Adams School Redevelopment

Addendum No. 3 to Contract Documents

March 30, 2012

Avesta Housing Development Corporation

TABLE 1: 4" THRU 10" FITTINGS

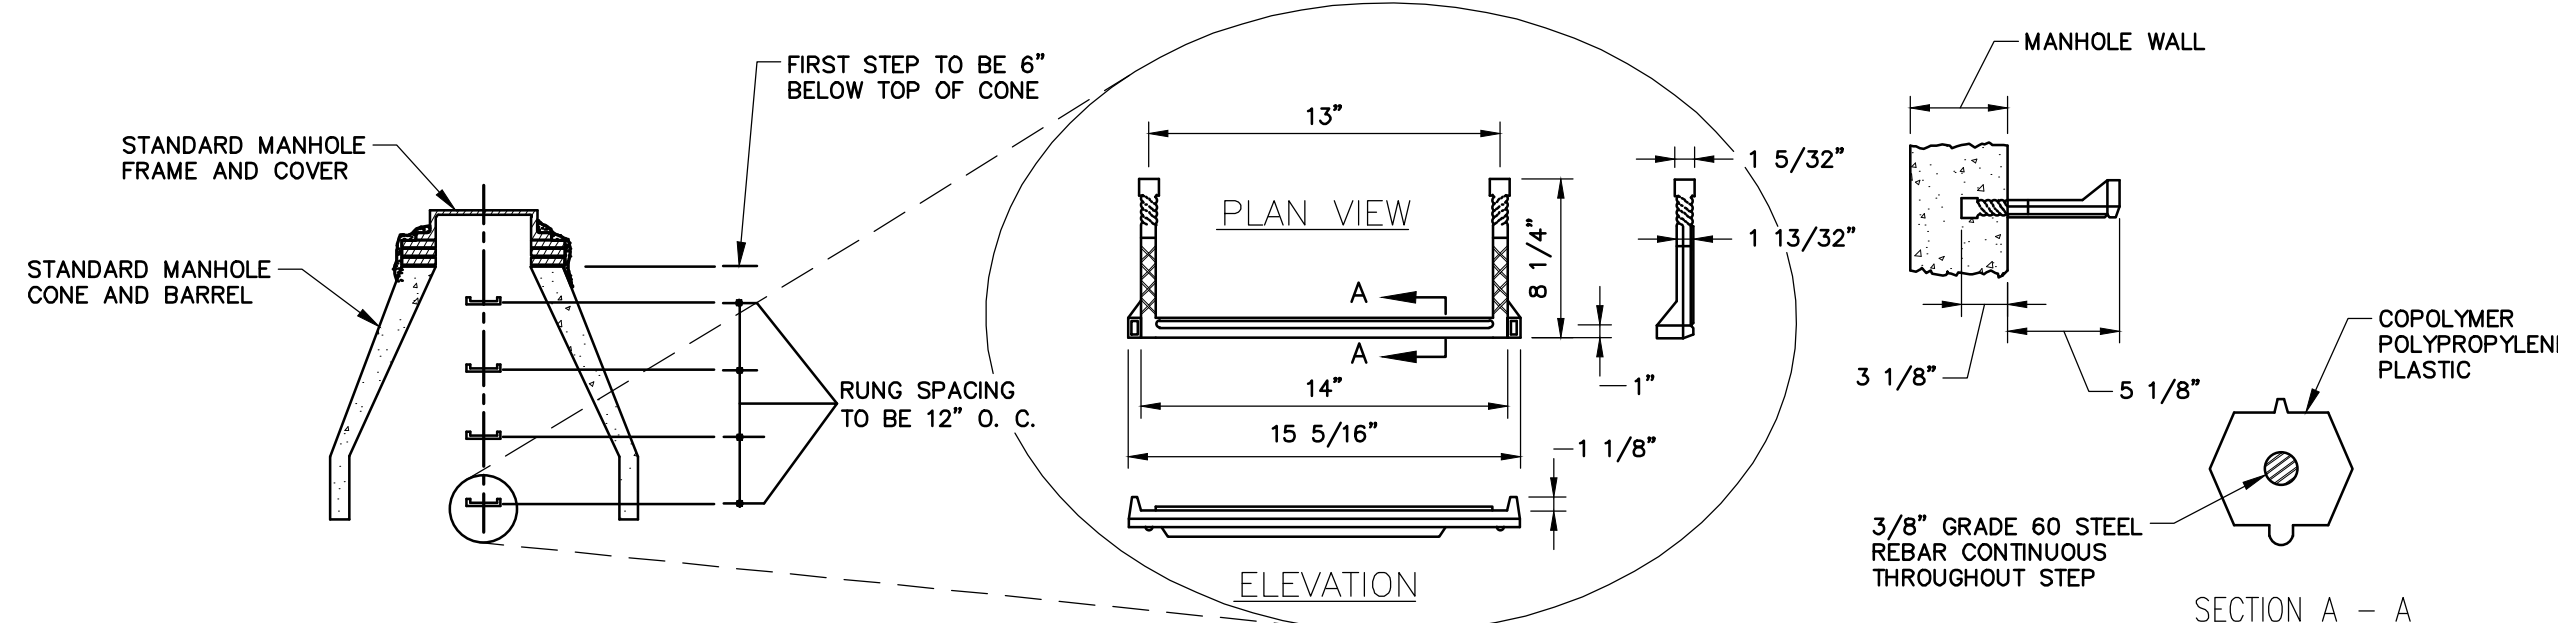
The water services should be constructed as shown. Note that ALL service pipe, on both the main side and building side of each valve will be type K copper tubing. A gate valve with valve box will be required on all service lines, in conformance with the detail provided on Sheet C5, and PWD requirements.

All service pipe will be type K copper tubing. No plastic pipe will be accepted.
